WEST SUSSEX COUNTY COUNCIL CONSULTATION

TO:	Arun District Council FAO: Mr S Davis
FROM:	WSCC - Highways Authority
DATE:	22 November 2019
LOCATION:	Rear of Inglenook Hotel 253-255 Pagham Road Bognor Regis PO21 3QB
SUBJECT:	P/58/19 Erection of 9 No. dwellings with associated access, parking, cycle & refuse storage & landscape design. This application is a Departure from the Development Plan & may affect the setting of a listed building. Additional information received.
DATE OF SITE VISIT:	20/11/2019
RECOMMENDATION:	More Information
S106 CONTRIBUTION TOTAL:

Scale	1:500	Drawn By	SMO	Checked By	ALB	Approved By	PMR
Date	October 2019	Project No	2017-3763-001	Page			B

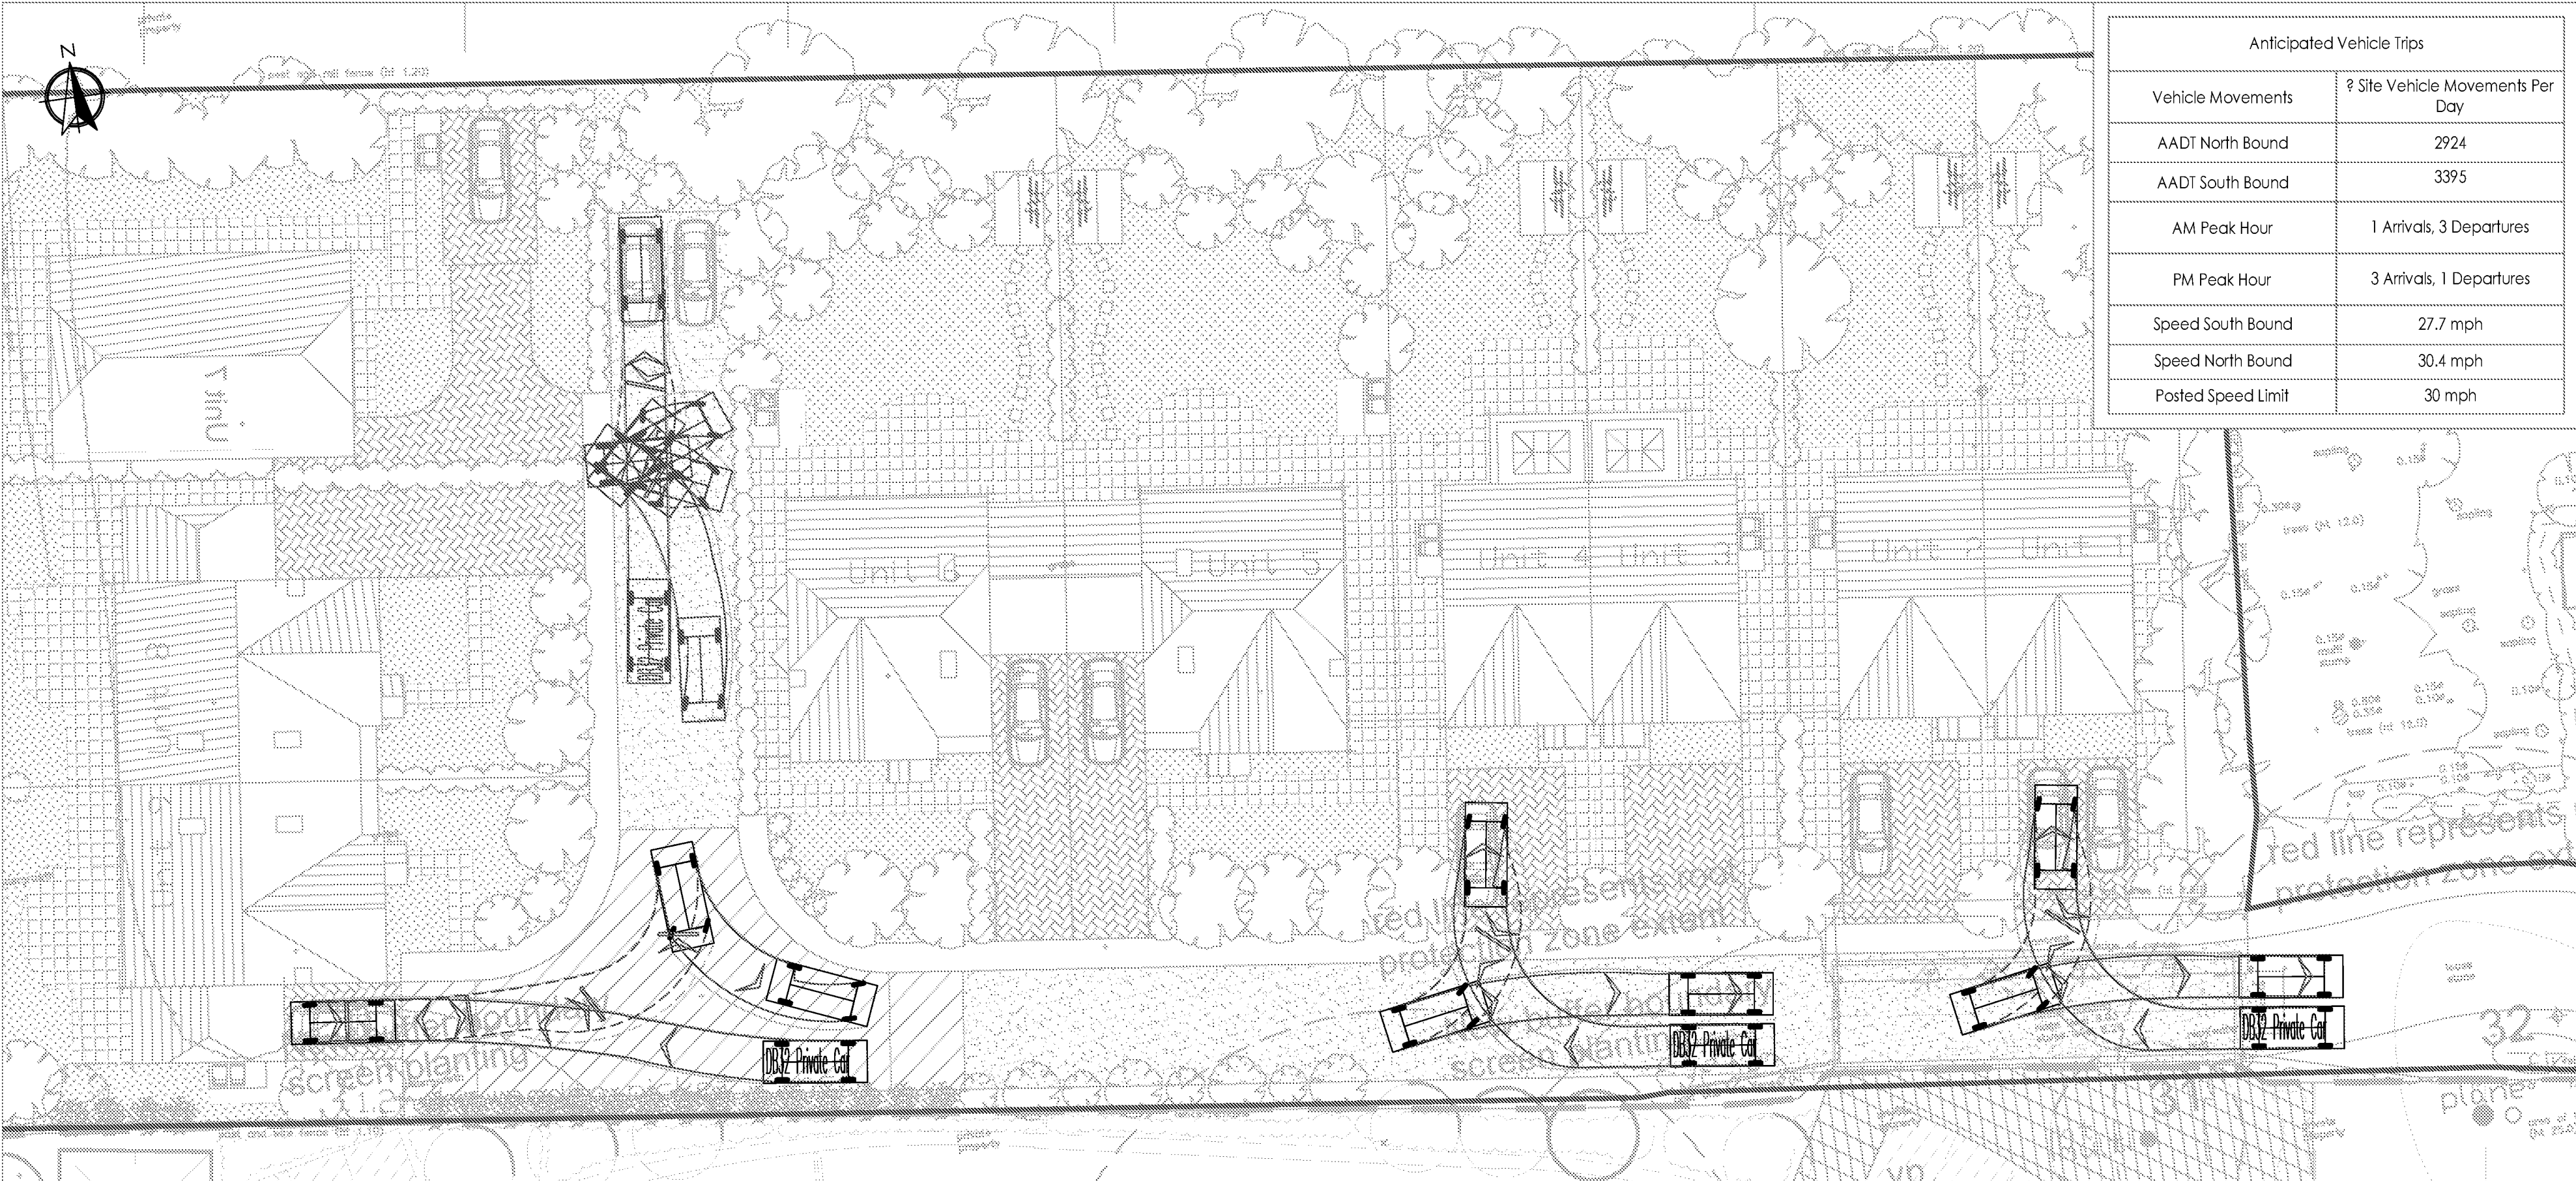
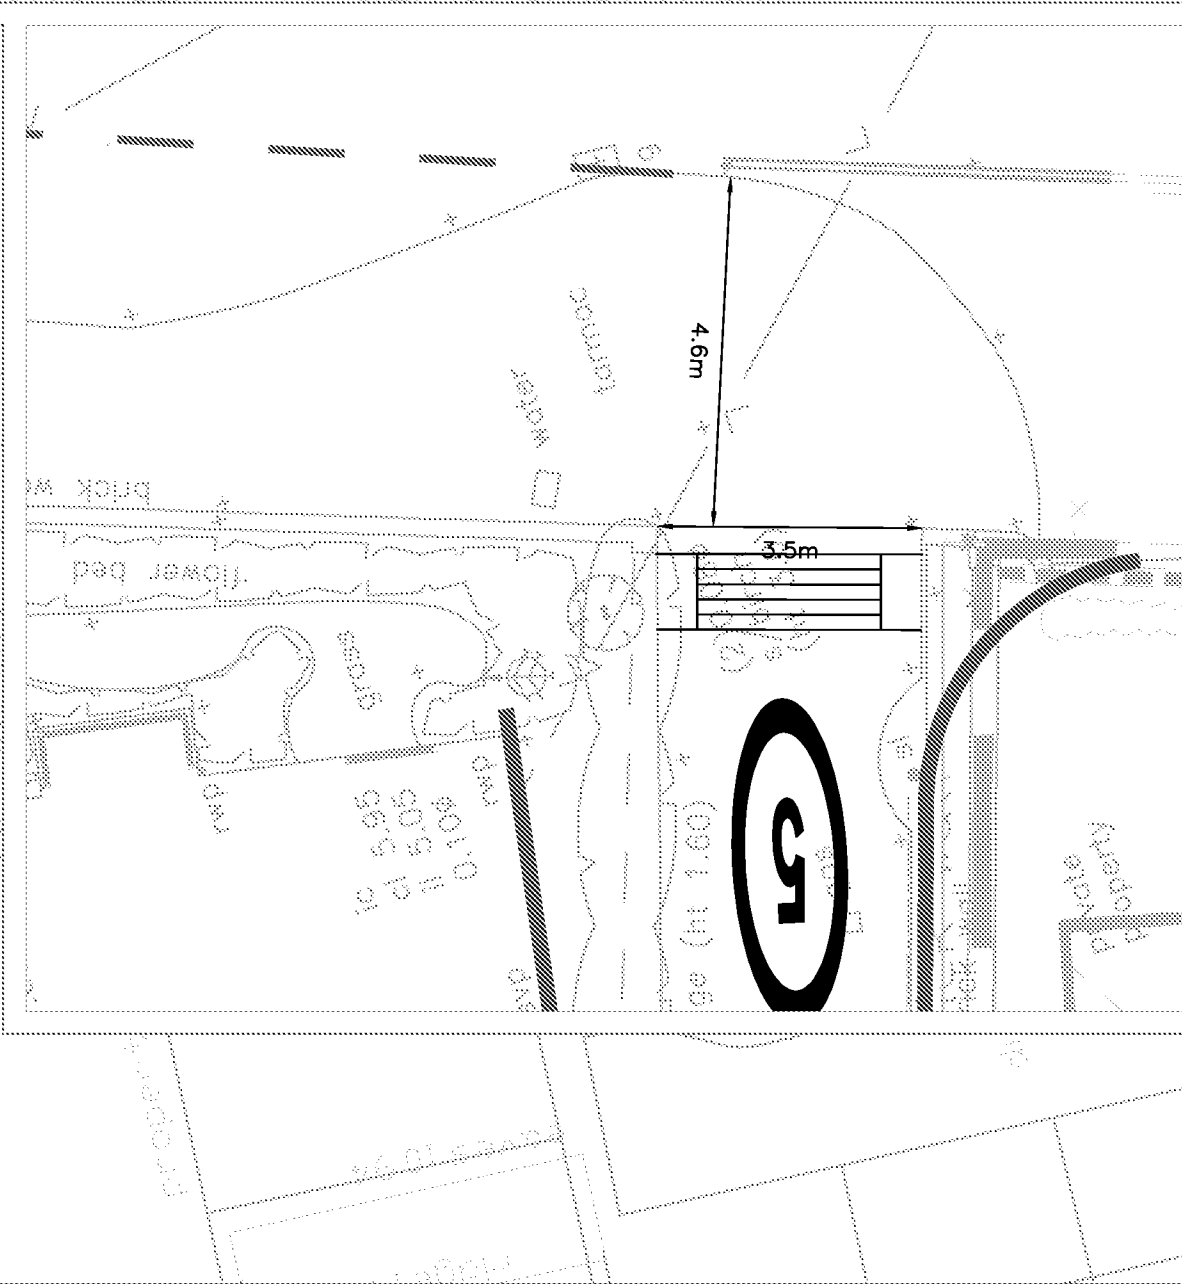
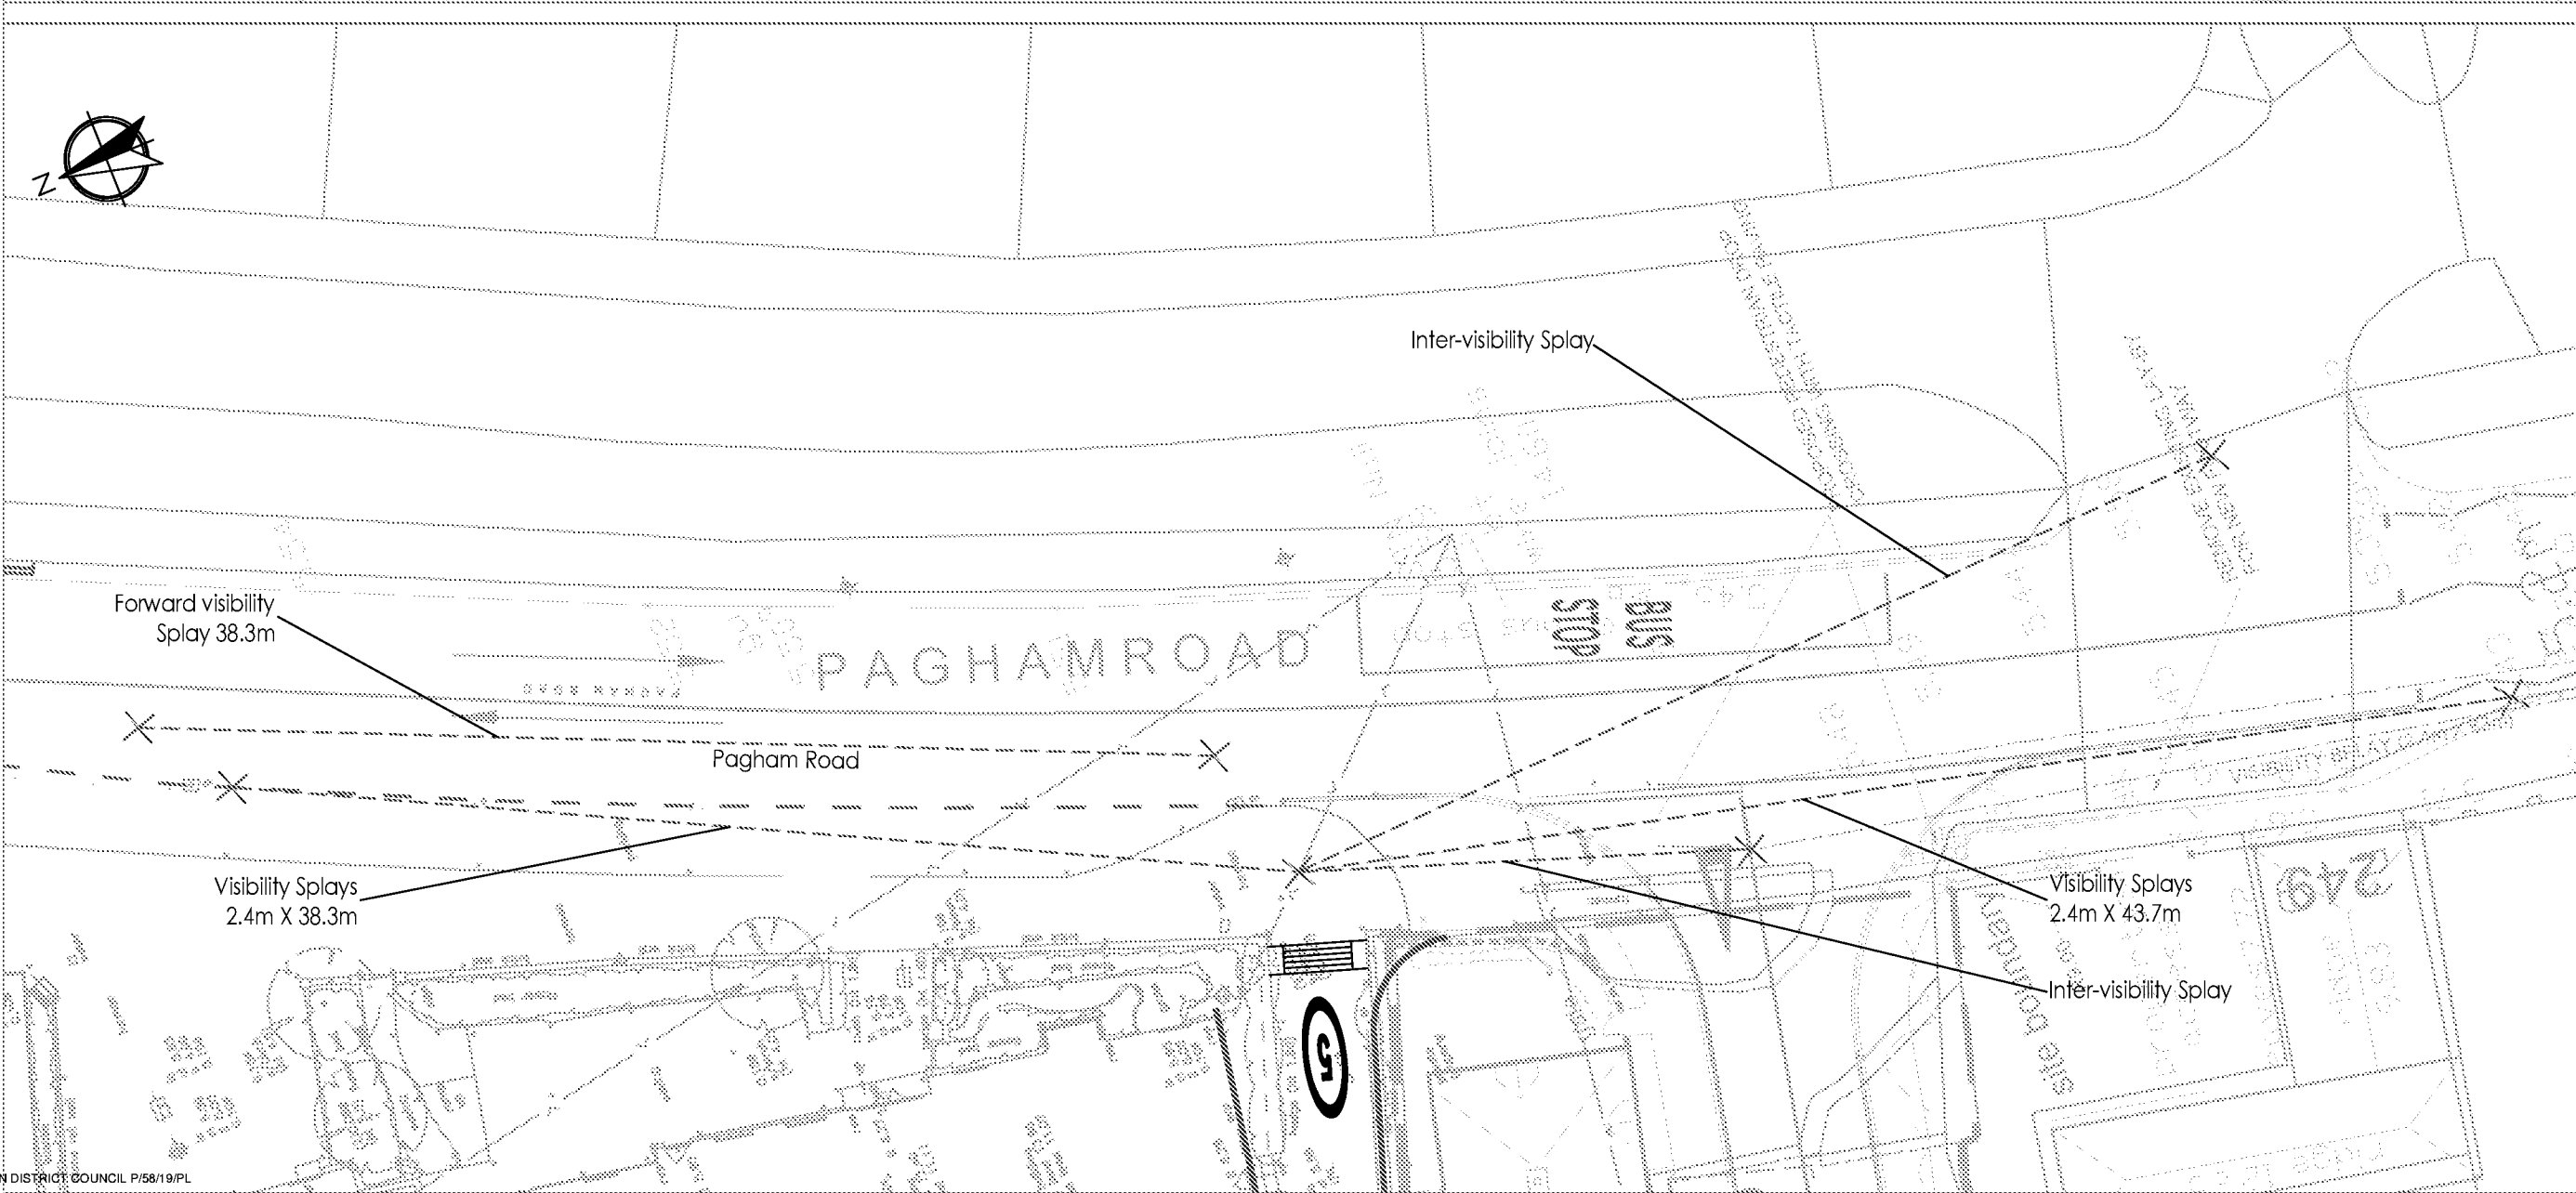
There is a left hand turn along the access route as the road meets the existing car park. Currently on the inside of this bend, along the eastern boundary with the neighbouring Crayfern site there is a line of trees which may restrict the visibility splay for emerging vehicles and pedestrians. The LHA note that the existing forward visibility splays intersect this tree and vegetation and that there is scope for improvement. It is not clear whether this will be present in the final design however; the applicant should demonstrate removal of this tree or cutting back of vegetation at this point to assist with visibility for all users. The forward visibility should then be redrawn to reflect these changes
